Submission on the Proposed Sky Safari at Taronga Zoo

Thank you for the opportunity to comment on the proposed development. My comments and objections are listed below.

Figure 22 Extent of potential works zone on Athol Wharf Road

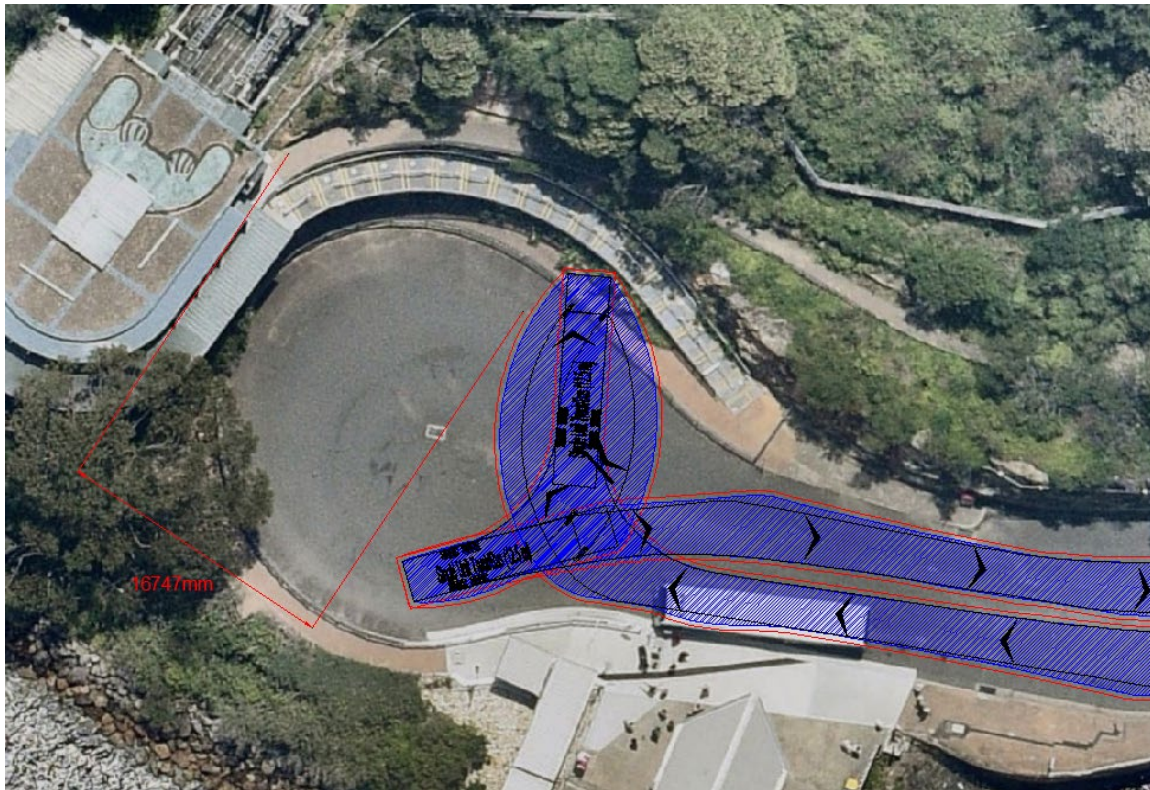
The proposal to create a construction work zone in the turning circle at the end of Athol Wharf Rd should be reviewed. The work zone in this location has a significantly adverse impact on the existing public transport arrangements because buses will not be able to negotiate any turn at the end of the road.

This is a public road and is used by the Bus 238 providing services to Mosman residents and to visitors to the Zoo, Balmoral Beach and Middle Head. The suggestion in the EIS is to use minibuses to take passengers between the wharf and the top gate of the zoo. This is not a practical solution because:

- i. these smaller buses might also find it difficult to turn around at the end of Athol Wharf Rd.
- ii. having regard to the large numbers of zoo visitors there would need to be a high level of shuttle buses at any one time, and this would add to increased congestion.
- iii. a switch to shuttle buses at the top gate will make the service more unreliable for local residents who use the ferry and bus for transport to the Quay and home. Many use it every day for journey to work travel

Importantly, the EIS states that the construction will occur on Zoo land but then includes the Athol Wharf Road for the staging of the removal of existing Lower Station and the construction of the new Station. This is a public road. Alternative construction approaches must be developed.
